SUBJECT: **On-Call Contract #17-067H-1; PO#8113073**
Bridge Reviews
Task Order #6: Mesa Top Bridge Submittal – Third Review

This memorandum provides a list of comments for the 3rd Submittal of the Mesa Top Bridge, based on requirements in the County's Engineering Criteria Manual (ECM), 2019 CDOT Standard Specifications for Road and Bridge Construction, Current CDOT Bridge Design Manual and the Current CDOT M&S Standards Plans.

FOREST LAKES FILING NO. 6
 BRIDGE HYDRAULIC INFORMATION
 MESA TOP DRIVE OVER NORTH BEAVER CREEK

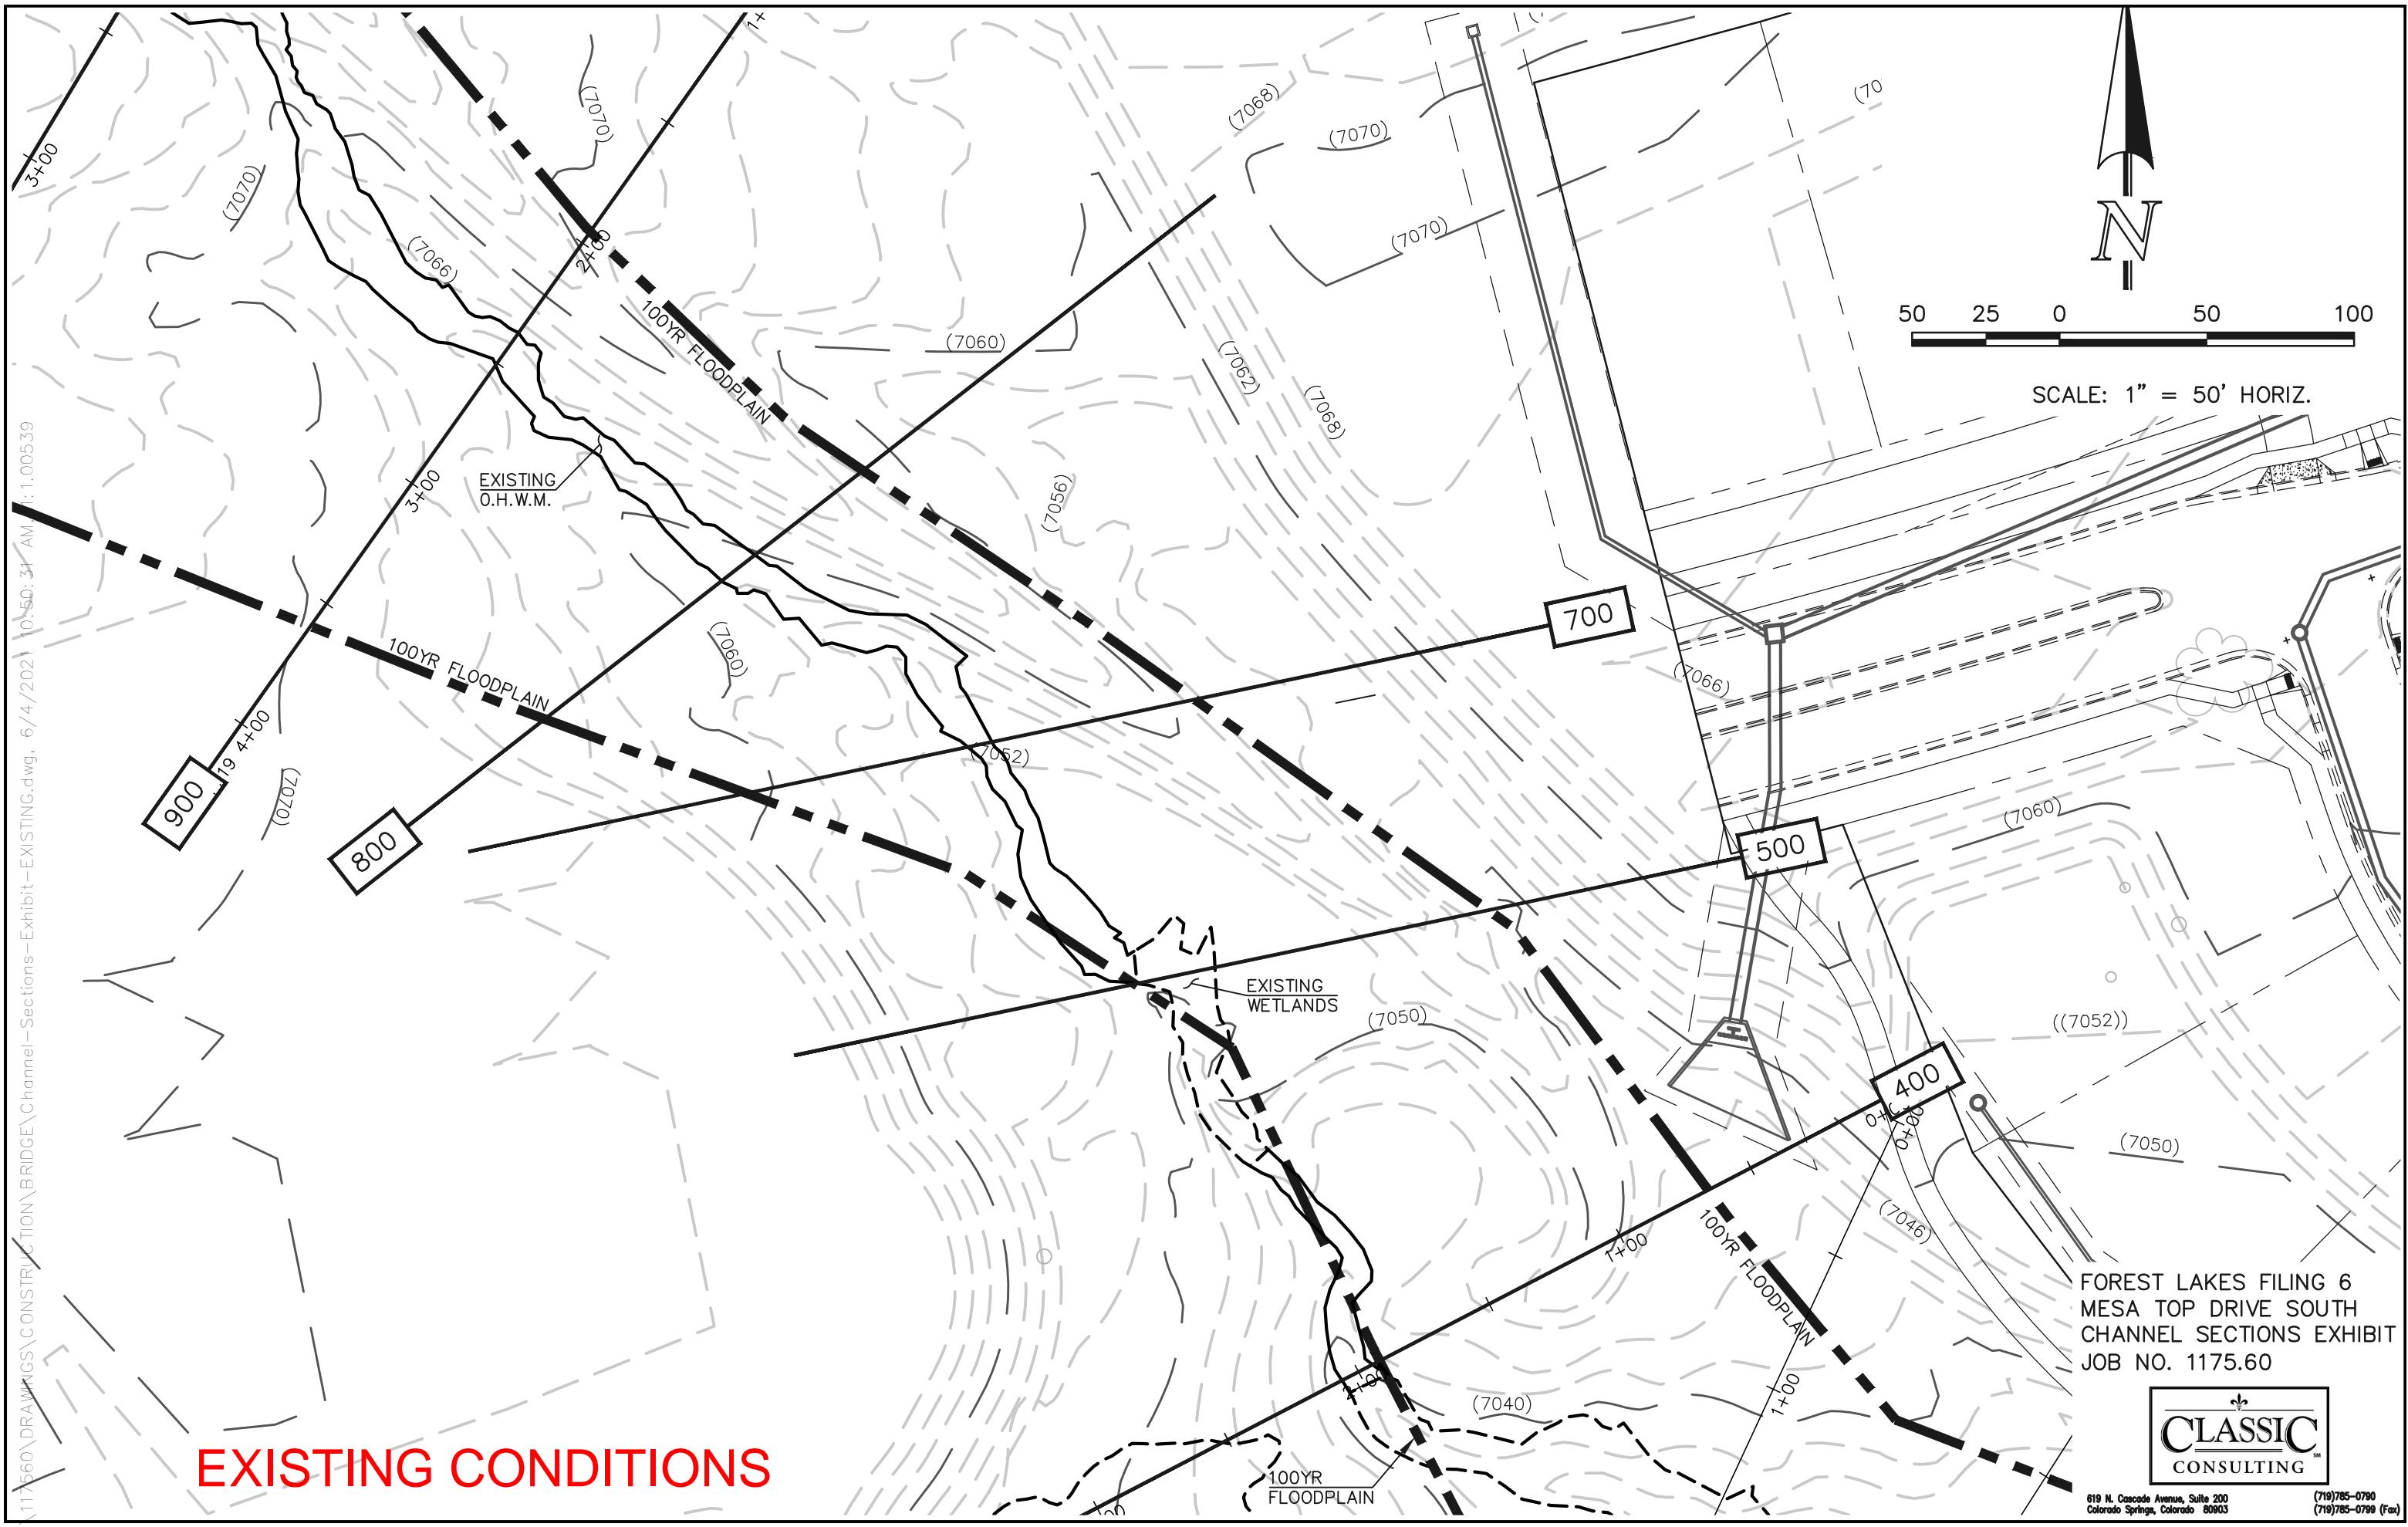
1. How are the plan view limits of riprap being defined? What is the riprap size? Is there bedding or geotextile proposed? (Comment 1 from this section in Second Review memo).

2. Show scour limits (Comment 2 from this section in Second Review memo).

RESPONSE: As reflected on the "Bridge Hydraulic Information" sheet in the Appendix, 24" rip-rap is proposed over Mirifi fabric to a point 5' horizontally from the toe of slope and with 1' off freeboard as reflected in the sections.

RESPONSE: Scour limits are provided within Scour Analysis section of report. We can add to Plan View sheet if desired.

**CHANNEL SECTIONS
EXISTING CONDITIONS**

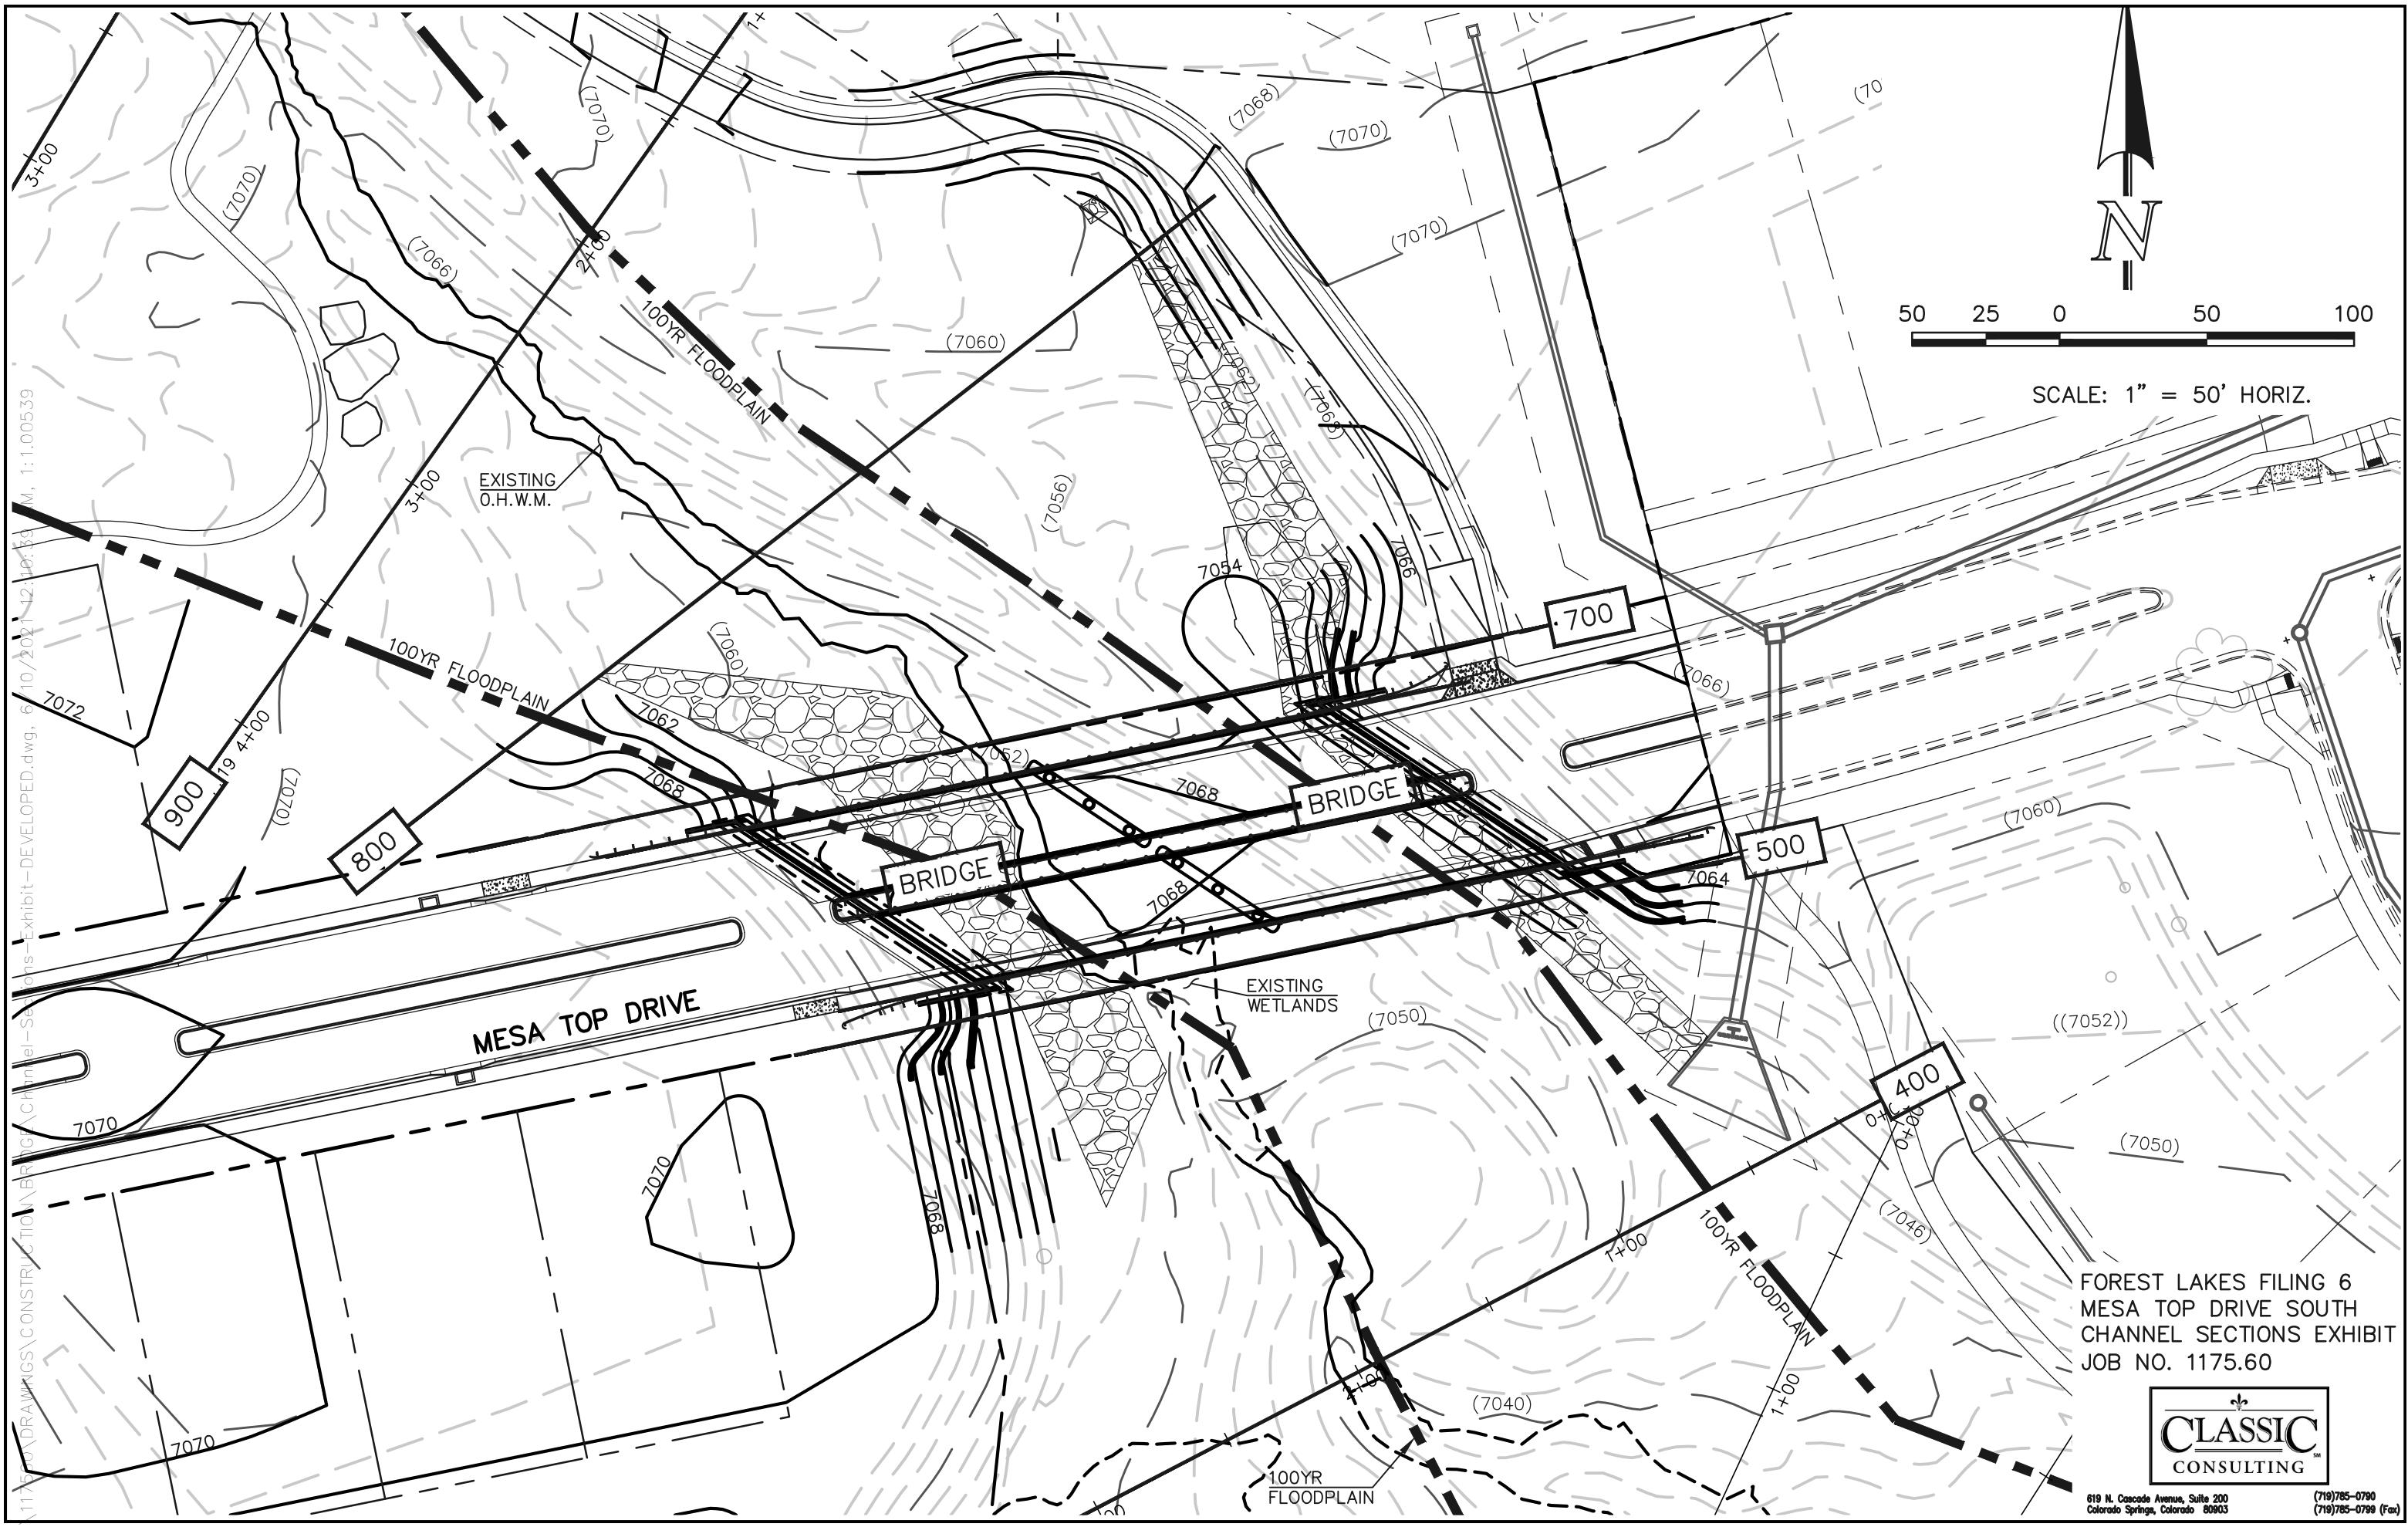
1. Proposed conditions section 700 shows encroachment for both Qs (3123 and 1932) on the left overbank. The contraction coefficient for that section should be increased. A typical value of 0.3 is often used.

RESPONSE: A 0.3 contraction coefficient was used as reflected in the modeling provided to Elizabeth.
